TO: Margaret L. Haynes, P.E.
New Mexico of Transportation (NMDOT)

Julie Luna
Bernalillo County

RE: Review of Albuquerque VA Cemetery TIA (Dated December 11, 2024)

SUBJECT: Response to Comments

ATRISCO VISTA BOULEVARD ROAD IMPROVEMENT PLANS

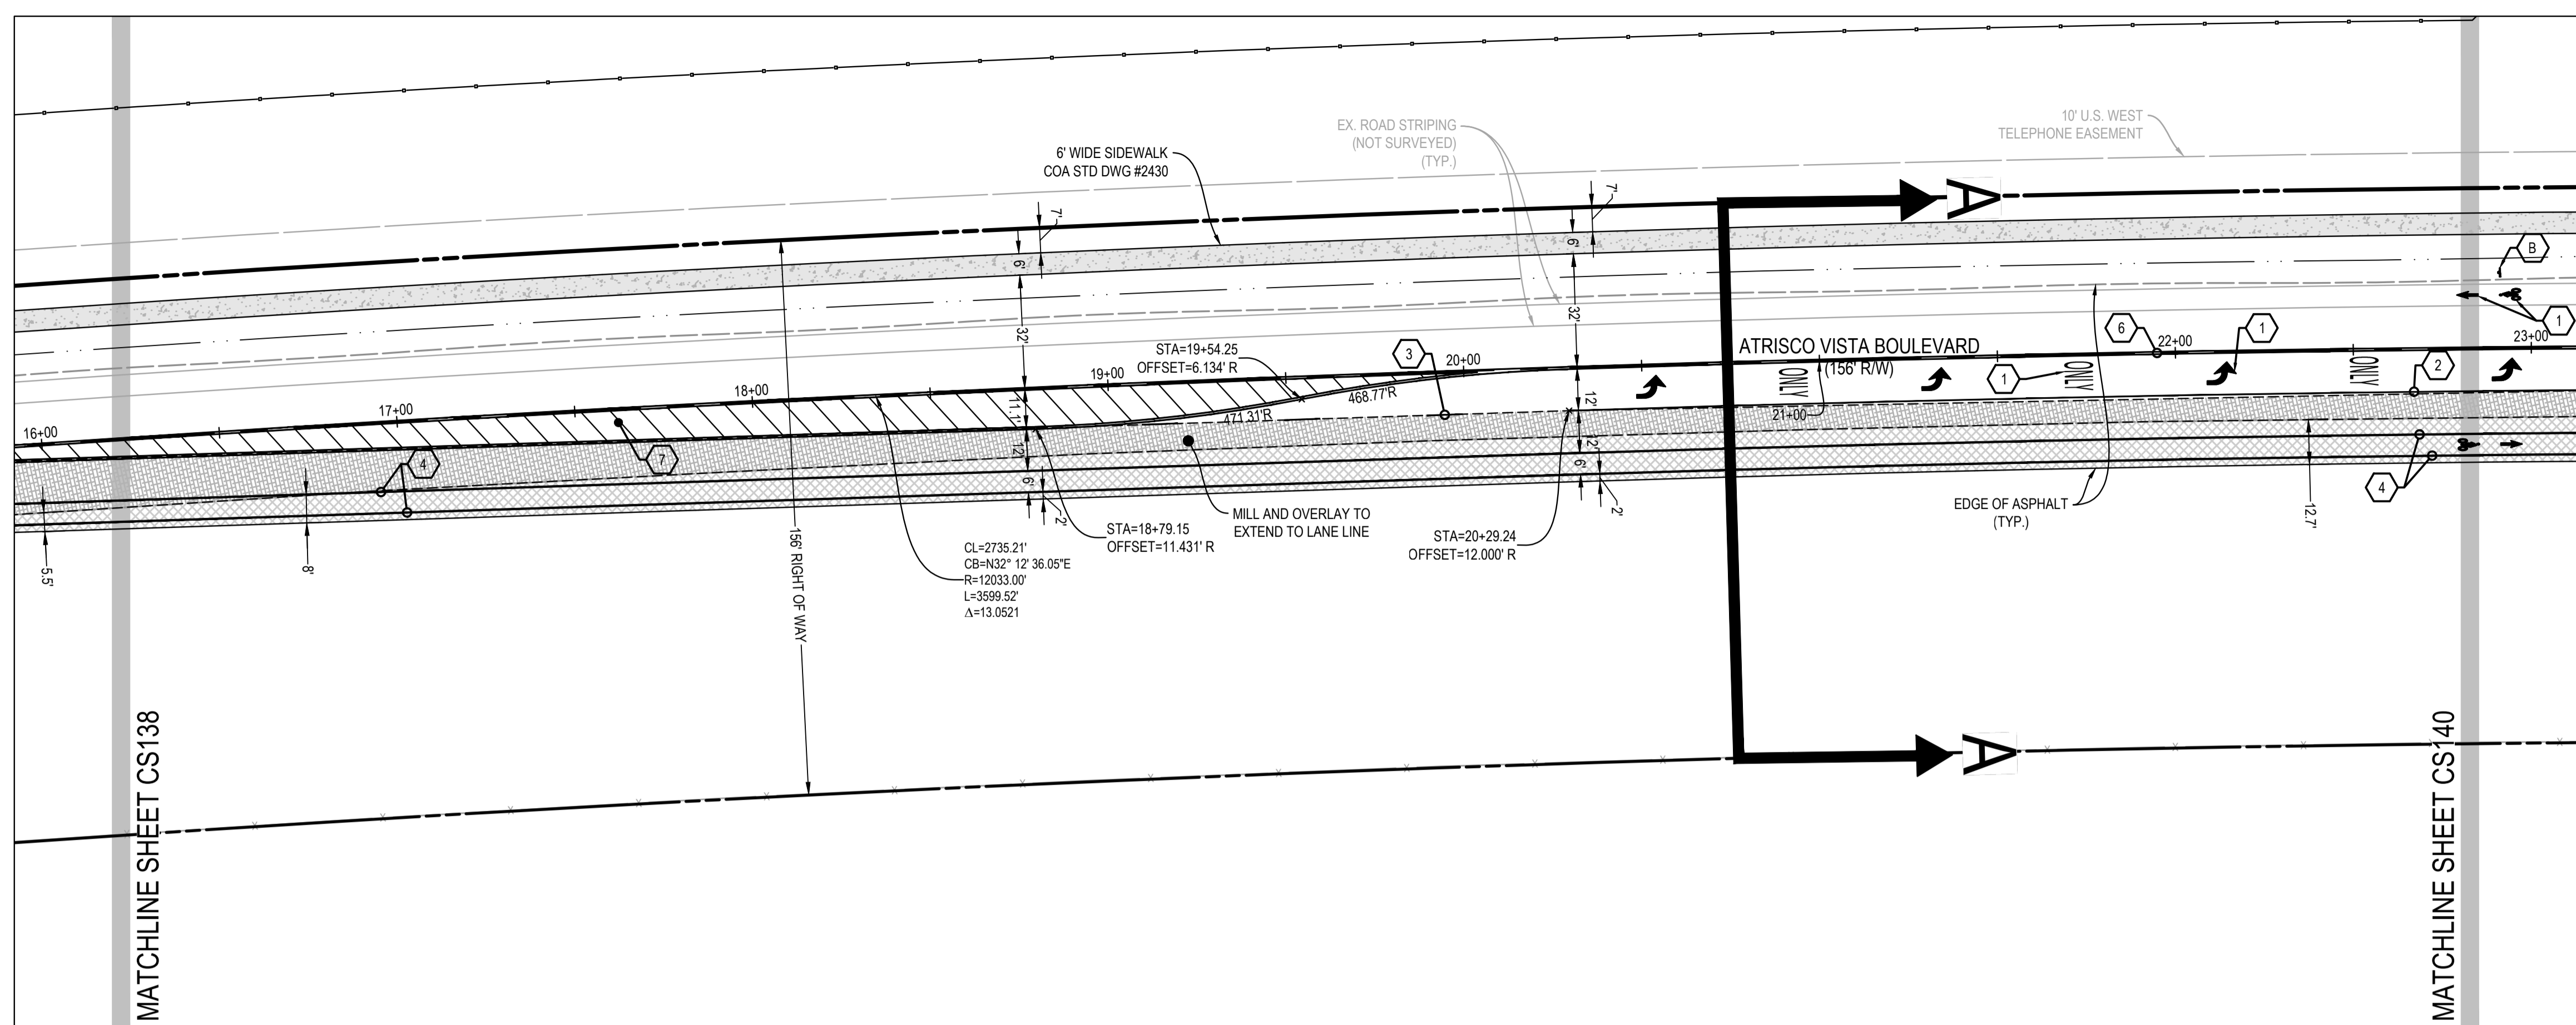
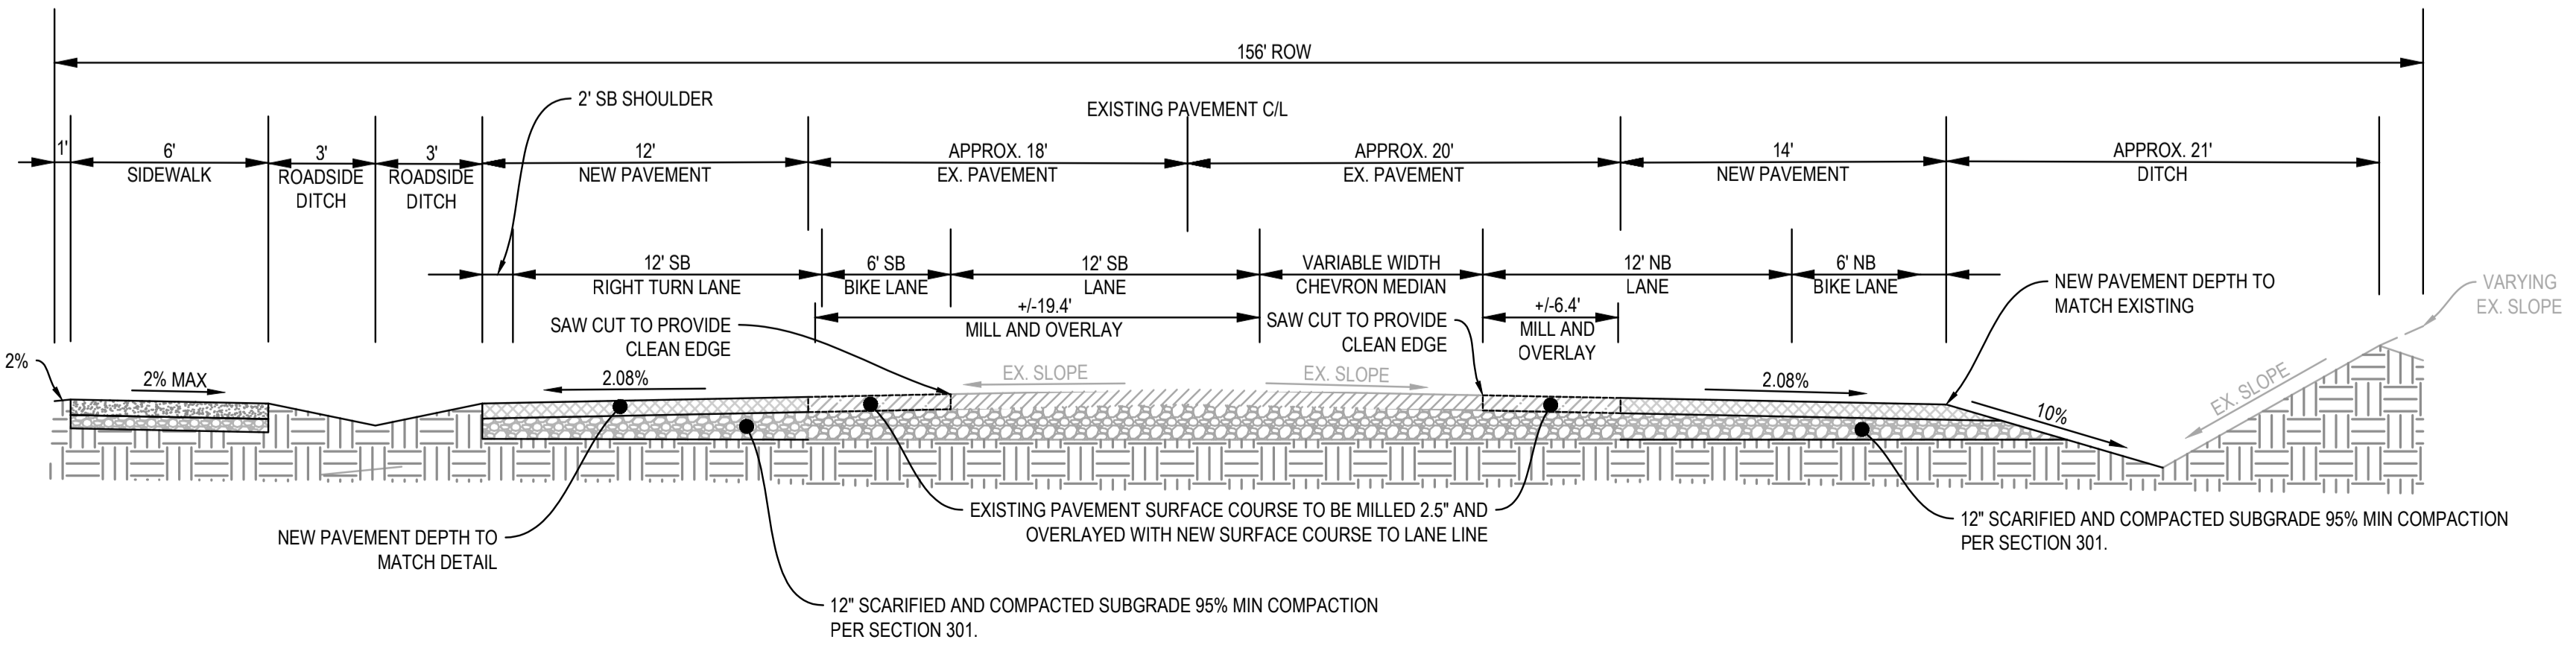
Comment 2: Intersection 10 Auxiliary Lanes – a left turn only lane is required by Bernalillo County at Intersection 10. Although it does not meet BC's warrant (that is intended for more urban environments), the left-turn only lane is required for safety concerns. The site plan on page 8 (Figure 2-1) includes a right-turn-only lane, but on page 37, #5 states that none is required. BCPW Transportation Planning will not require a southbound right turn only lane.

Comment 3: Site Frontage – The adoption of the Upper Petroglyphs Sector Development Plan includes standard cross sections for frontages along public roads. Although development surrounding the cemetery is expected in later phases of the Upper Petroglyphs Plan, sidewalks along the site's frontage are required. A site further south along Atrisco Vista Blvd is developing and a draft cross-section has been provided. It is attached to these comments for information purposes. The sidewalk is required in ROW.

Response 2: Acknowledged.

Response 3: Comment noted. The design elements of the site frontage will be reflected on future site plan submissions.
